Application No: R/32/22/HH
Site Address: 30 The Parkway Rustington BN16 2BU
Description of works: Single-storey ground floor side extension. Conversion of garage to habitable use as an annexe to include a single storey extension.

Thank you for your internet representation made on 20th April 2022 which has been recorded as an objection with the comments as follows:

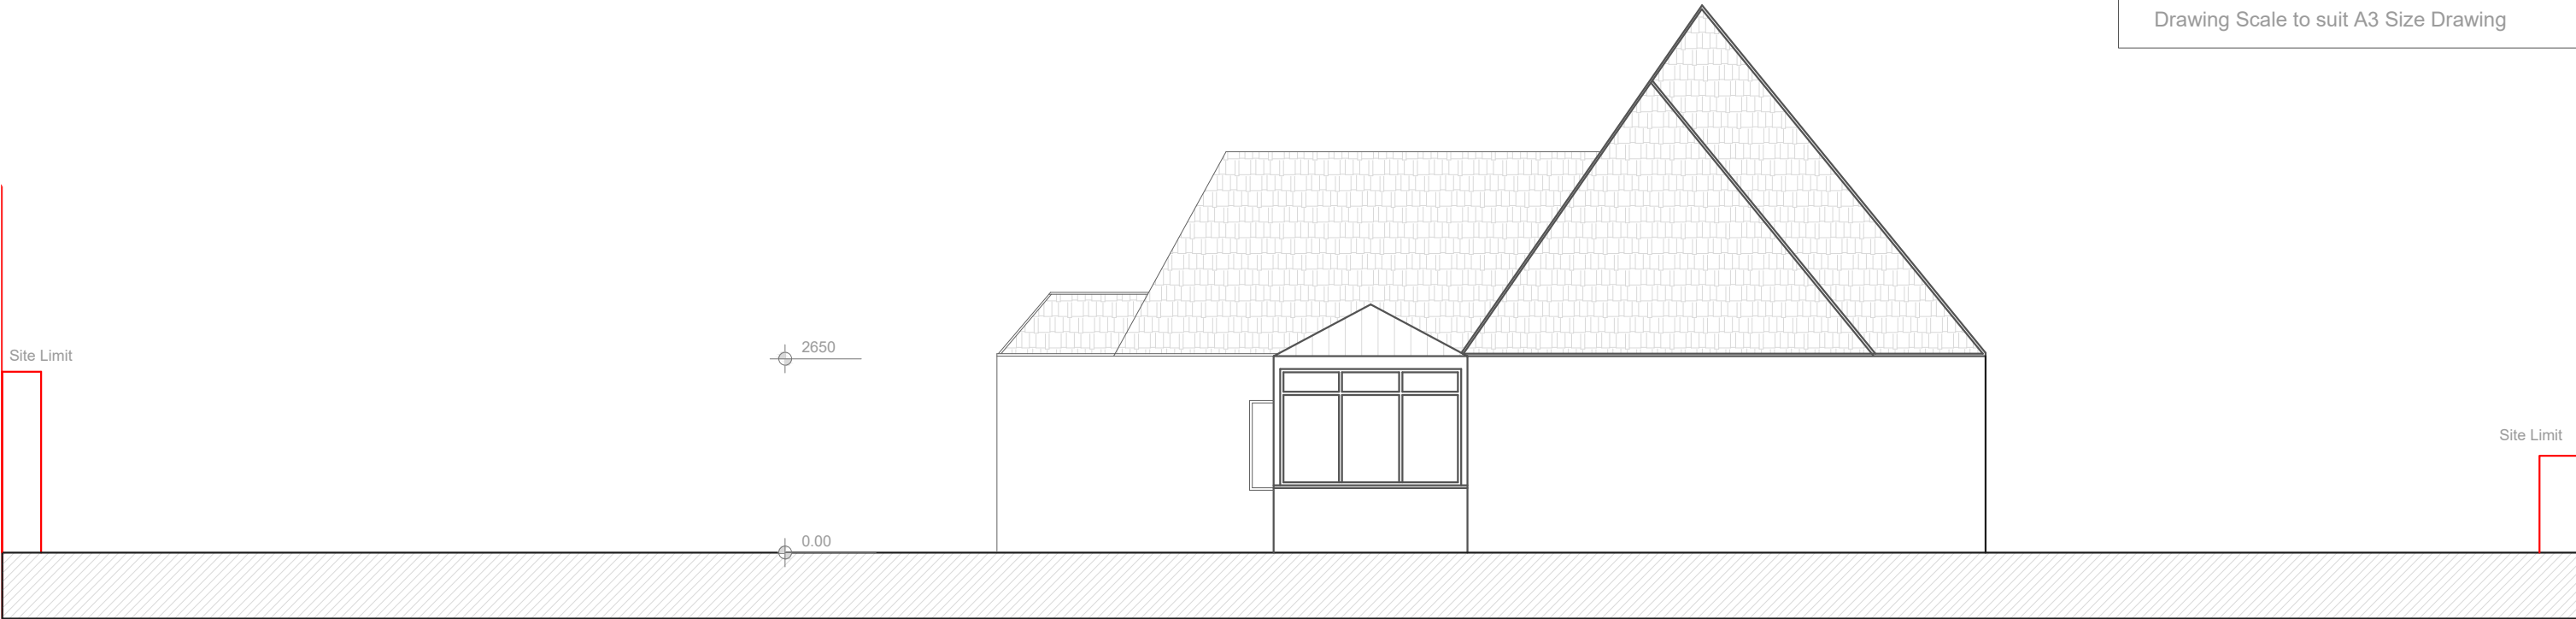
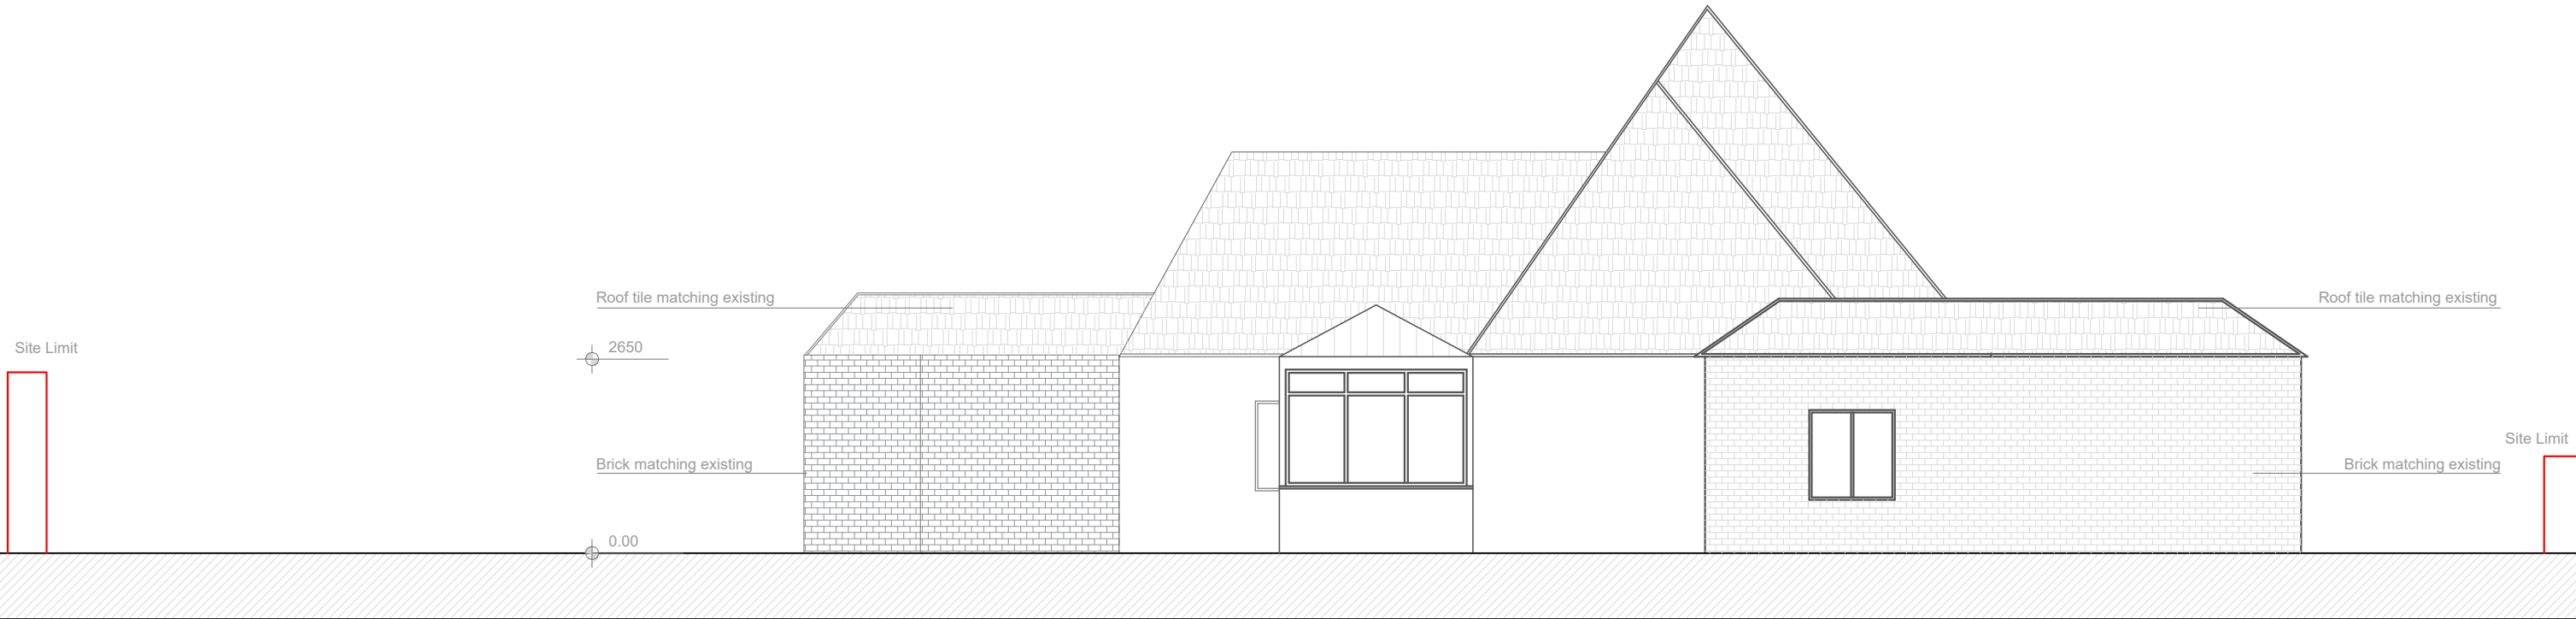
- We feel that the new build garage will be too overbearing and out of character, due to its size and the fact that it would have a pitched roof, and also would be far forward of the building line and therefore not in keeping with the rest of the properties in the road.

- The proposed plans show that the gap between the new build garage and the boundary with our property would be very small, with a side window looking directly onto us.

PROJECT NAME | House extension at 30 The Parkway, Rustington, BN16 2BU, UK
DRAWING TITLE | Planning Application Drawing - Proposed Block Plan 1/500

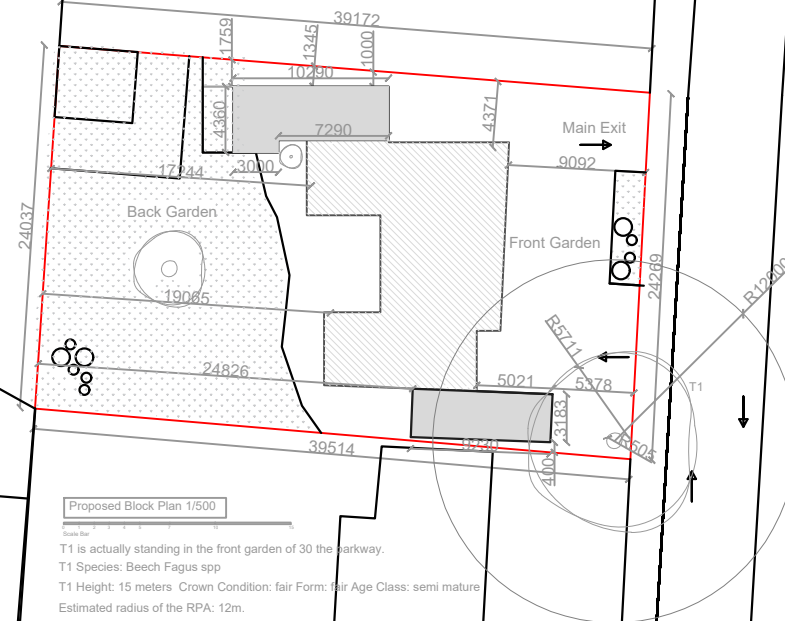
- The application and proposed block plan show that the Beech tree with the TPO is standing in the front garden of No. 30 The Parkway which is incorrect, and can be shown on council records that it is registered as being on No. 32 The Parkway.

- There are further discrepancies with some of the measurements shown on the proposed block plans, in particular those showing the gaps between the proposed new side garage wall and the boundary.
